Application for a non-material amendment following a grant of planning permission.

Number	<input type="text" value="21"/>
Suffix	<input type="text"/>
Property name	<input type="text" value="Royal Middlehaven House"/>
Address line 1	<input type="text" value="Gosford Street"/>
Address line 2	<input type="text"/>
Address line 3	<input type="text"/>
Town/city	<input type="text" value="Middlesbrough"/>
Postcode	<input type="text" value="TS2 1BB"/>

Site compound with erection of 3m and 2.6m high palisade fencing, creation of new door opening and installation of new air conditioning unit.

Reference number: 19/0443/FUL

Client: Home Office
 Project: Royal Middlehaven House
 Middlesbrough
 TS2 1BB
 Drawing: Proposed General Arrangement Plan

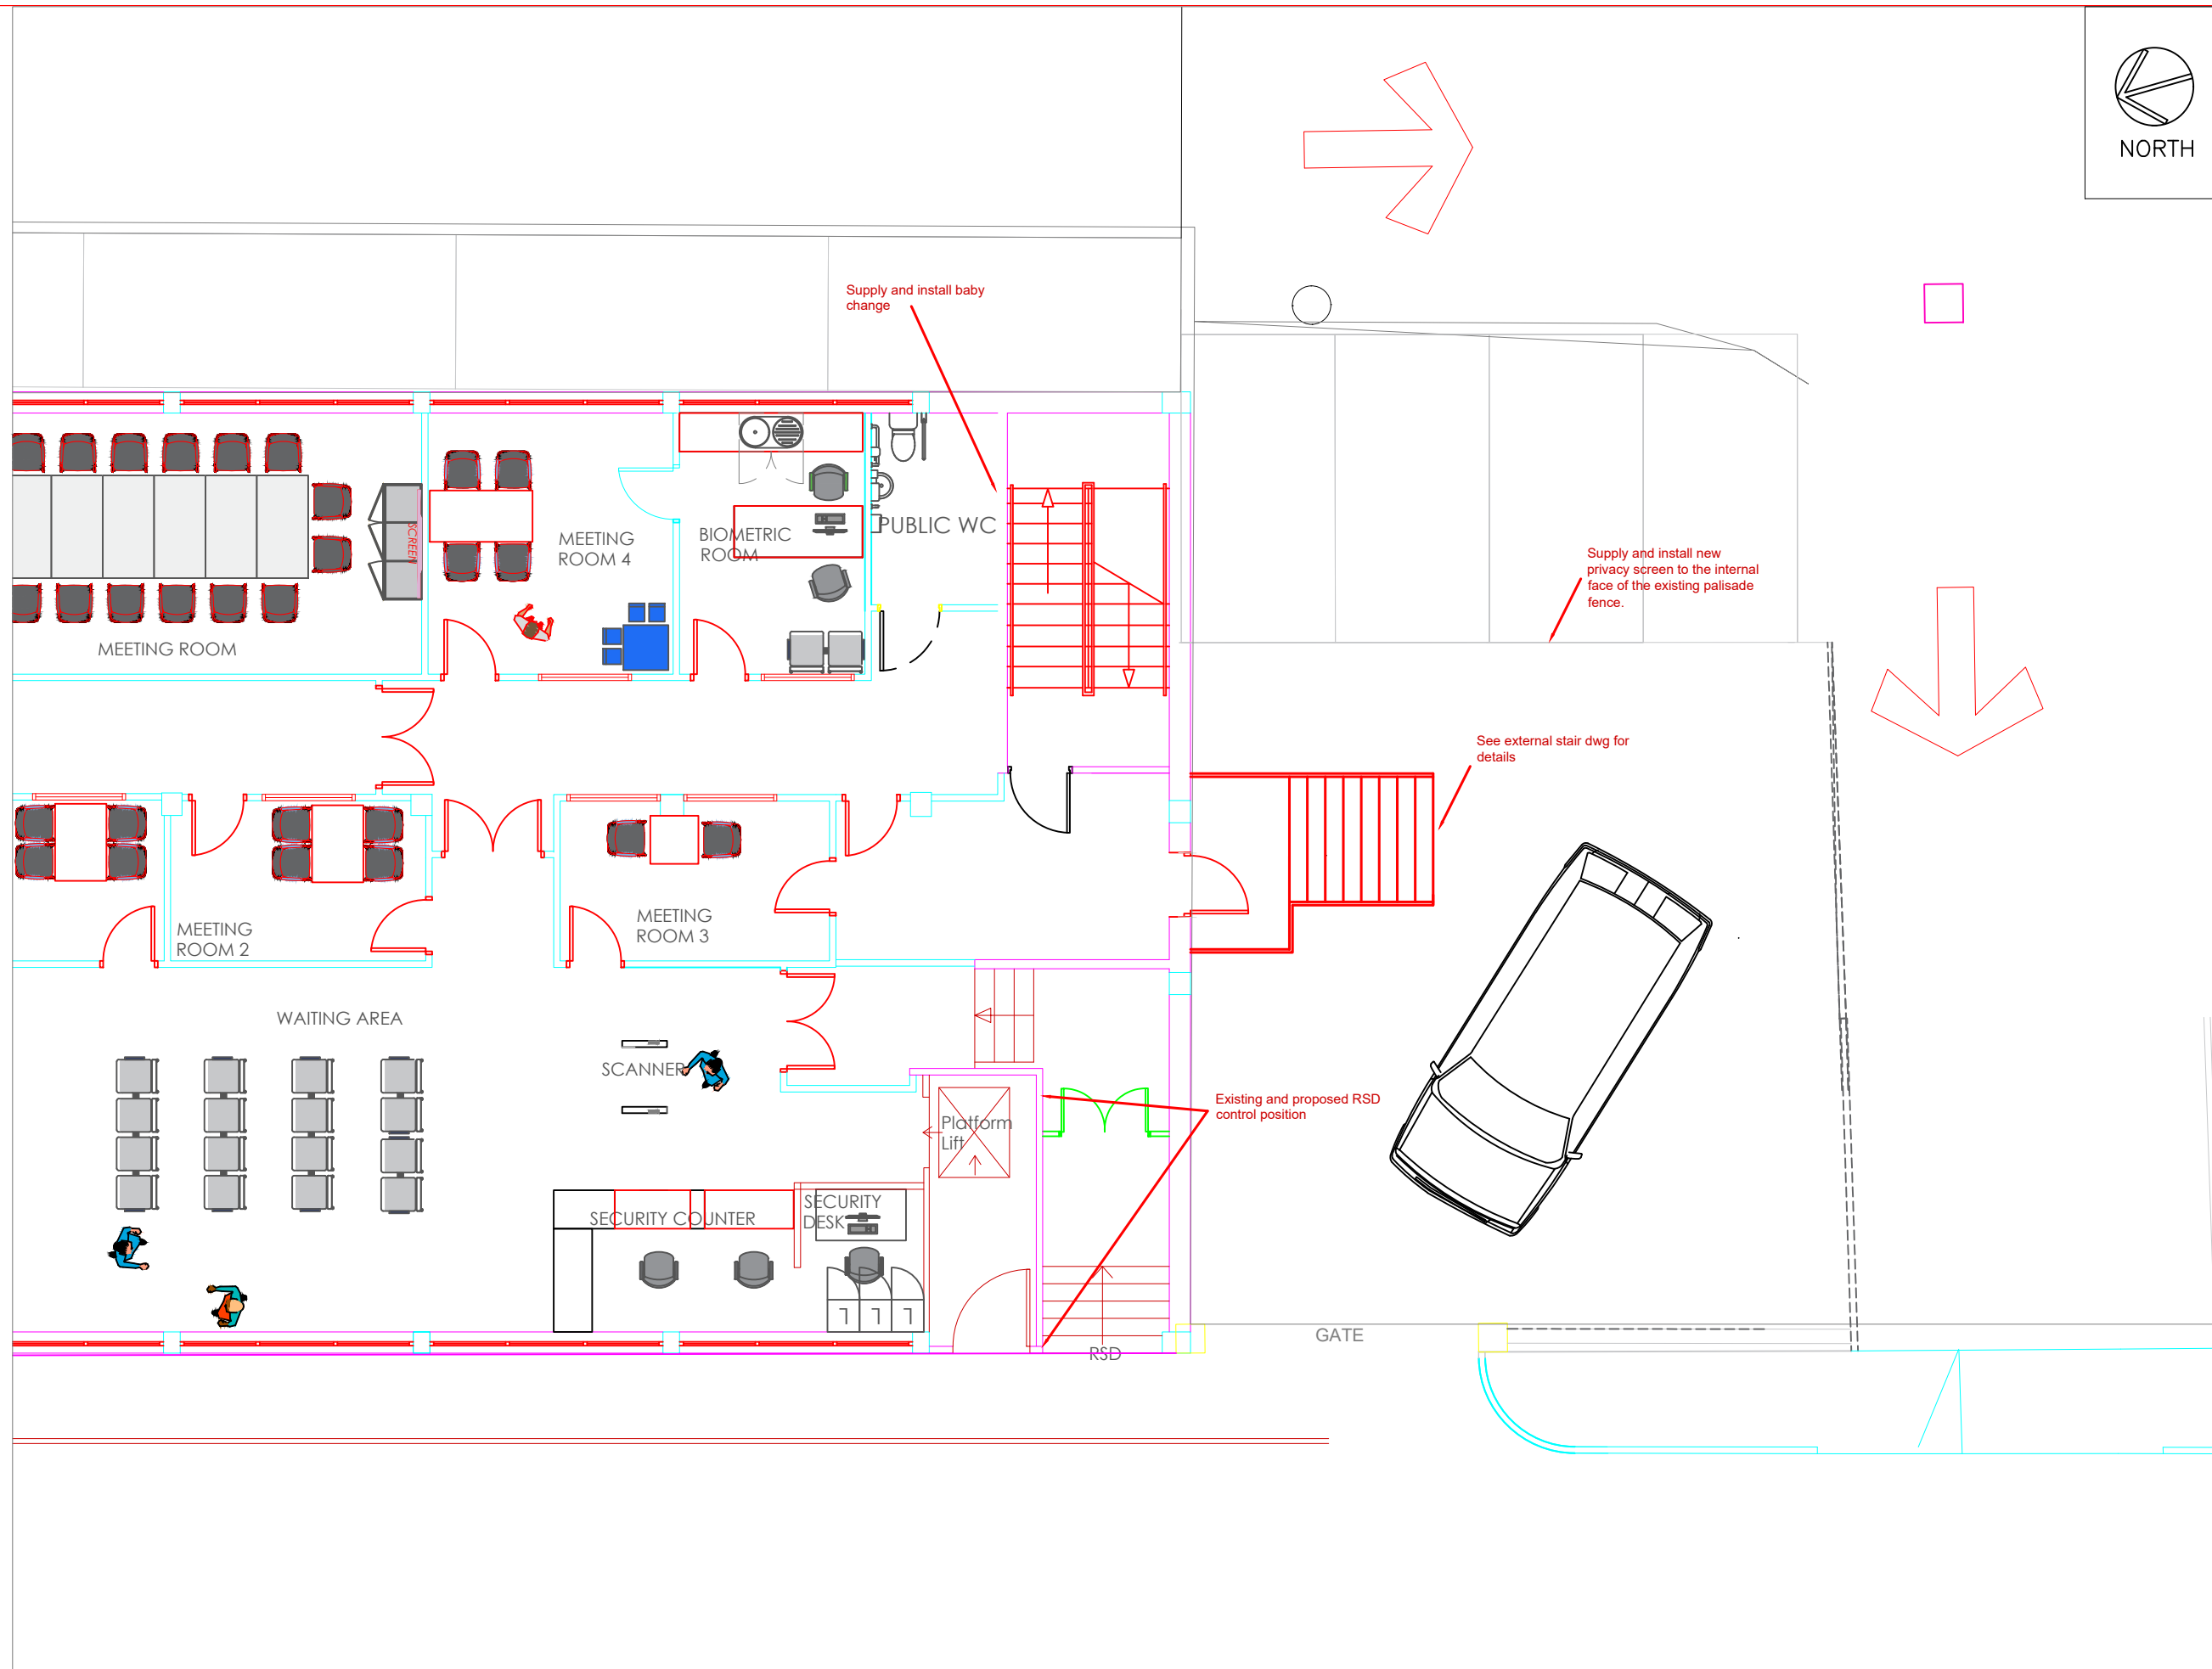
Amendments to the western elevation to include new doorway and removal of external ramp and replacement stairs on southern elevation.

# WEST ELEVATION

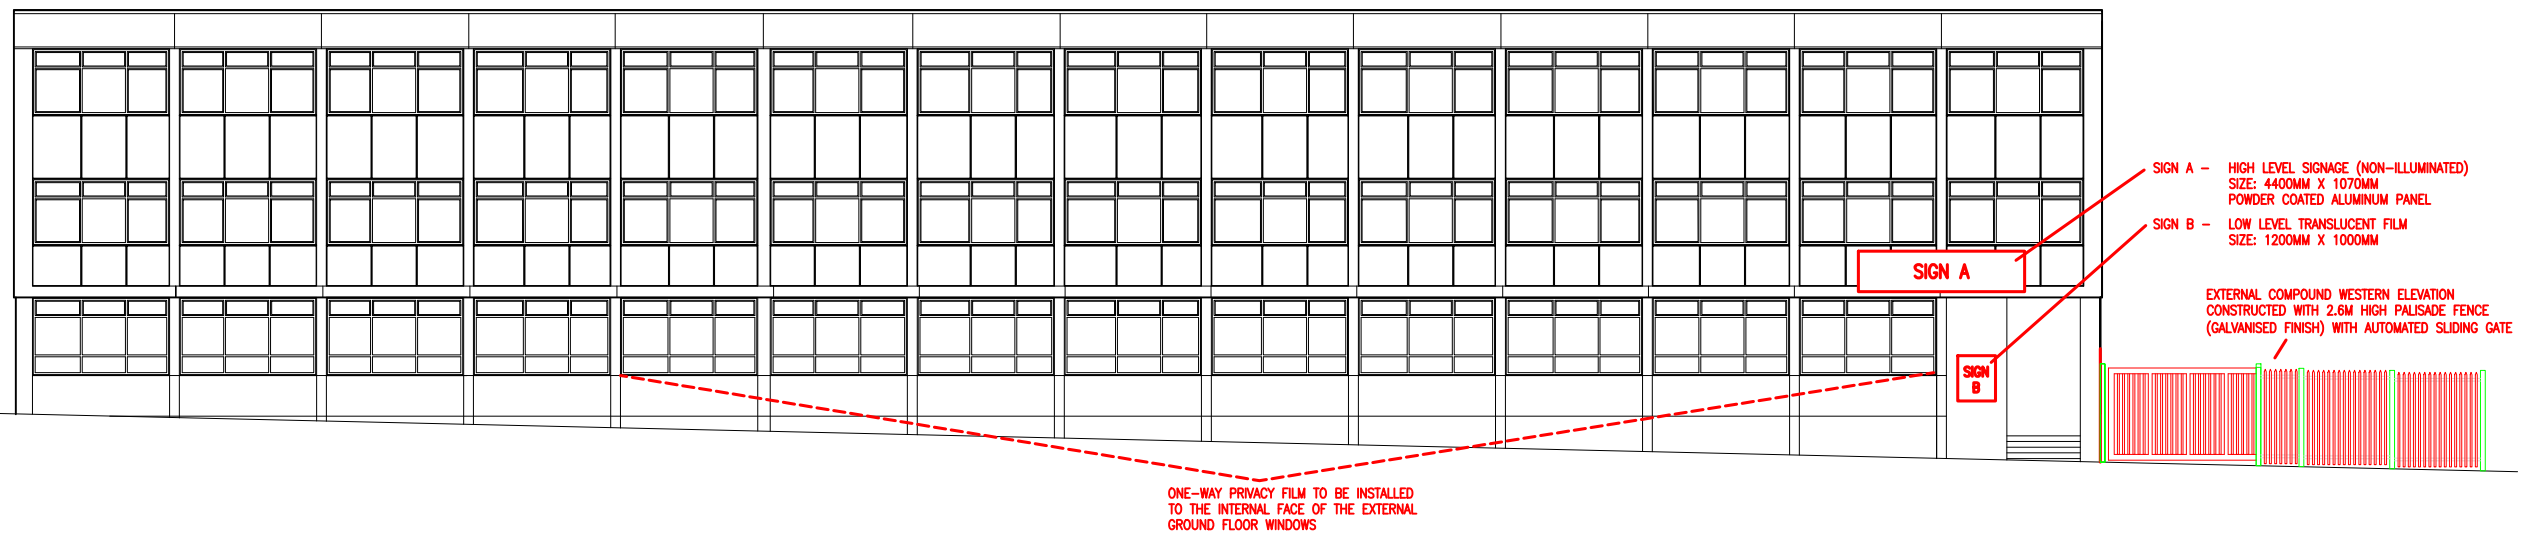
Partial substitution of Plan Proposed East/West Elevation (Eastern elevation to remain as permitted).

Client: Home Office
 Project: Royal Middlehaven House
 Middlesbrough
 TS2 1BB
 Drawing: Proposed West Elevation

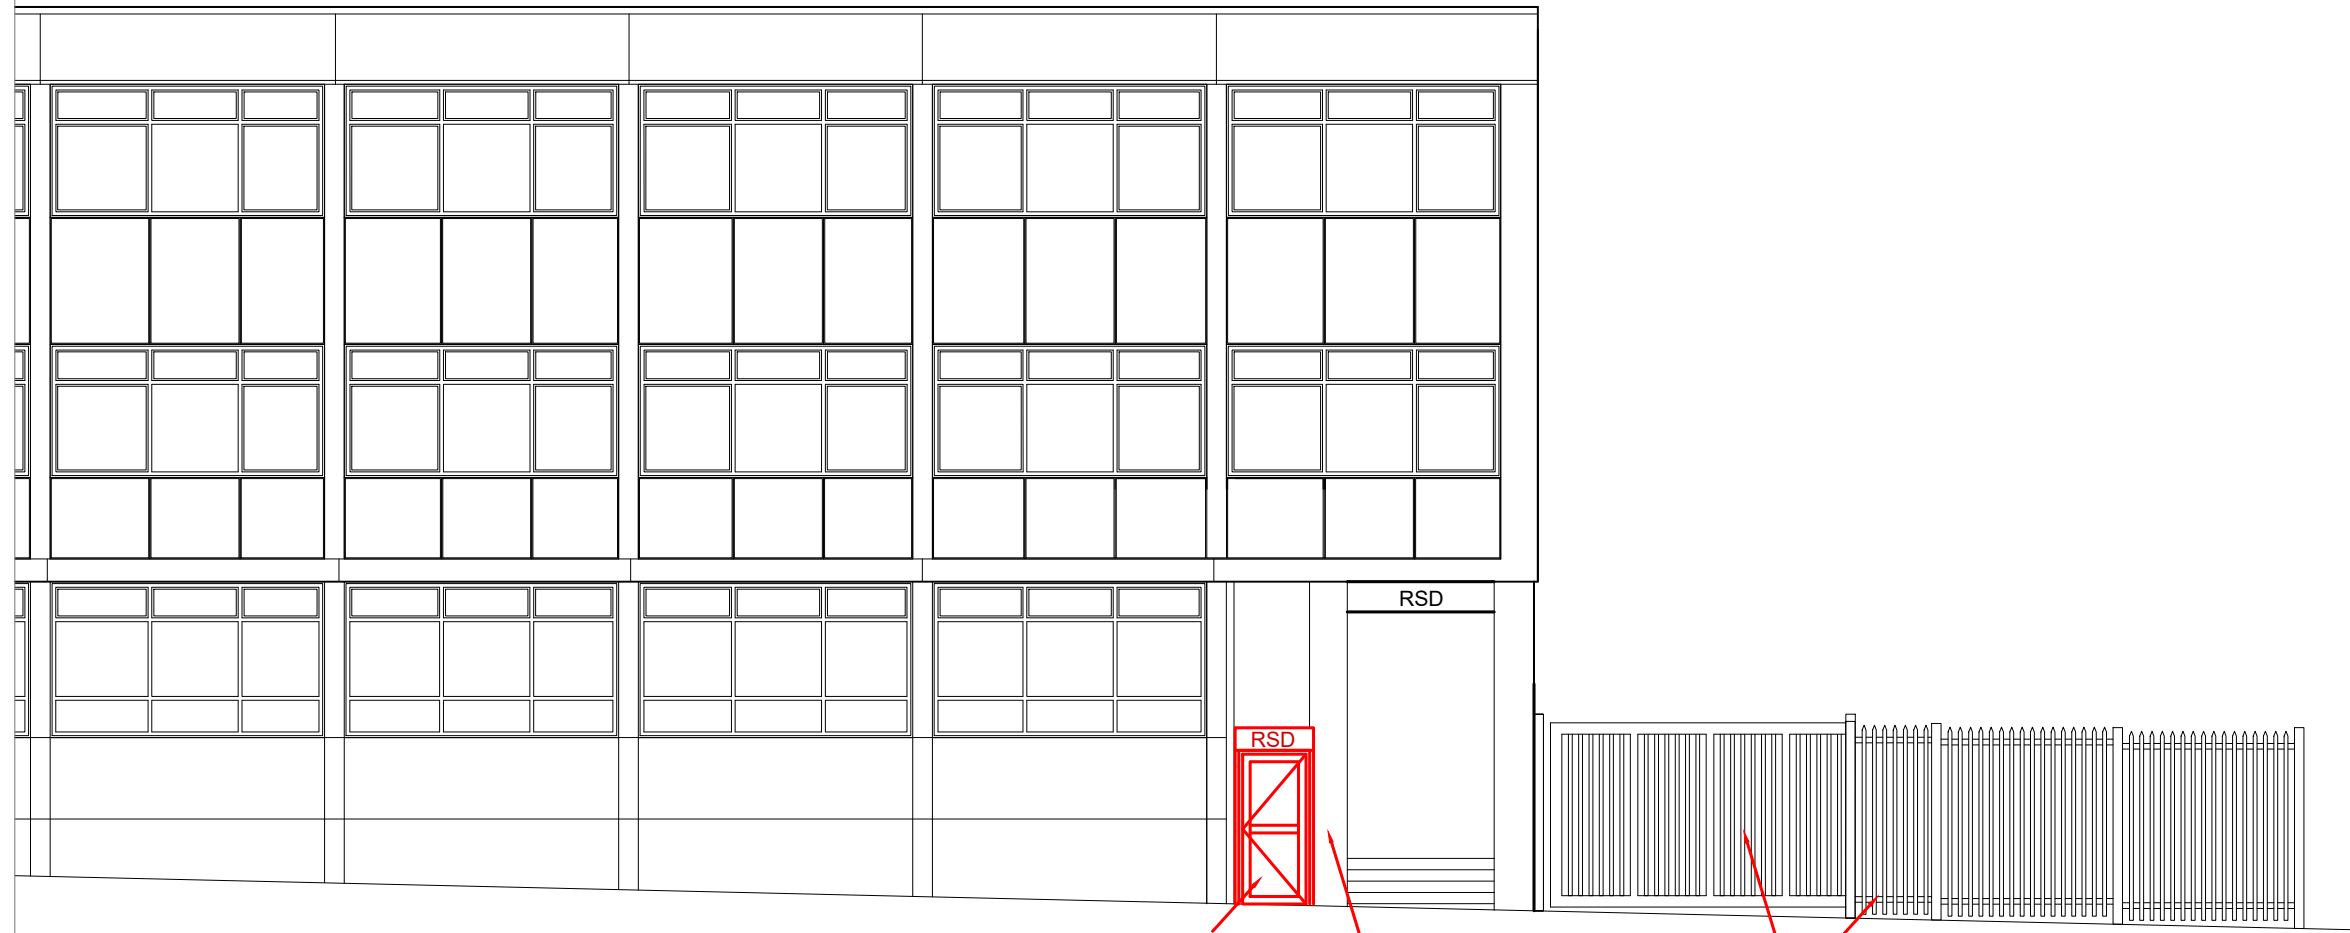
The amendment will enable the removal of the external ramp to be replaced by new stairs and the creation of a new external doorway to the western elevation.
